From: Simon Davis
Sent: 28 October 2020 15:56
To: Daniel OShea [REDACTED]
Subject: RE: P/97/20/PL - Summer Lane, Pagham

Drawing Title
Proposed Site Plan
105 Unit Scheme

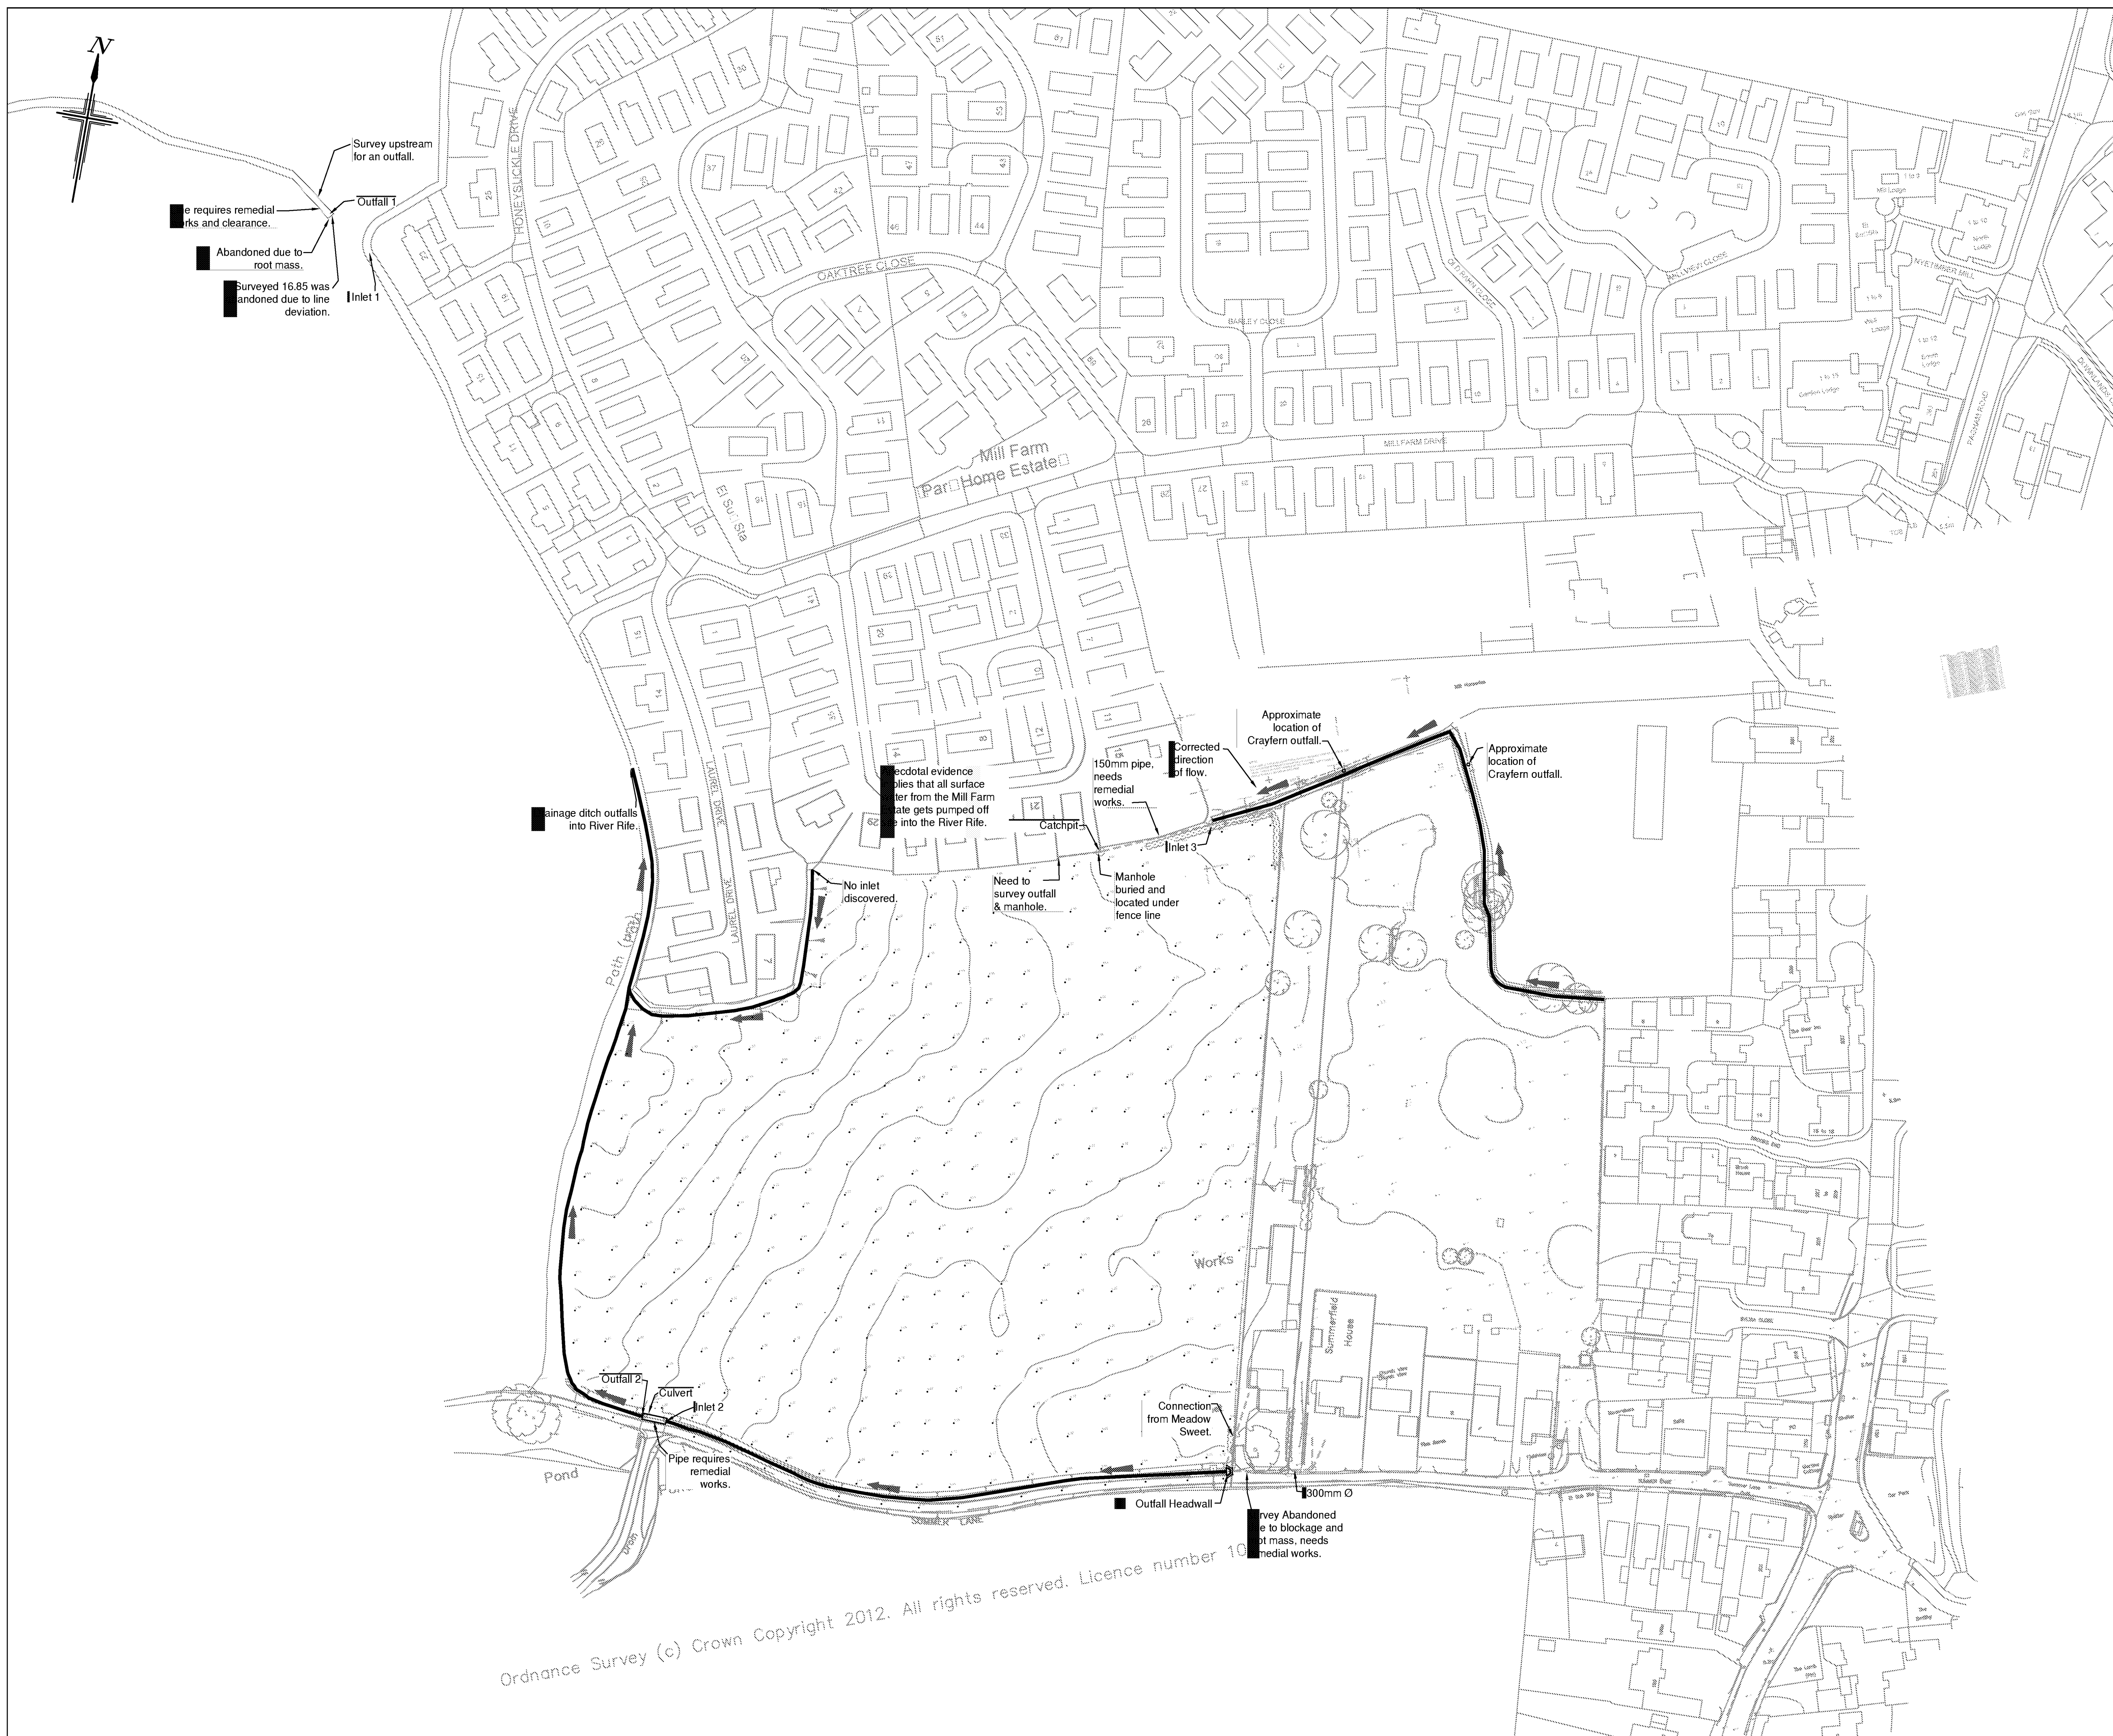
Thanks for this. I was reviewing the layout yesterday which included assessing the parking provision. Plots 52 and 81 should have 2 spaces each but because garages are only treated as ½ a space, only 1/5 spaces for each will be counted meaning a shortfall of 1. I think you have enough room on the layout to show an additional tandem space for 81 on the driveway. The remaining 0.5 shortfall would then be acceptable.

I note that the layout results in a loss of 3 approved visitor spaces but proposes four new ones. However, the visitor requirement for the 15 extra houses is 3 spaces so overall, there will be a shortfall of 2 visitor spaces. Would it be possible to provide these elsewhere?
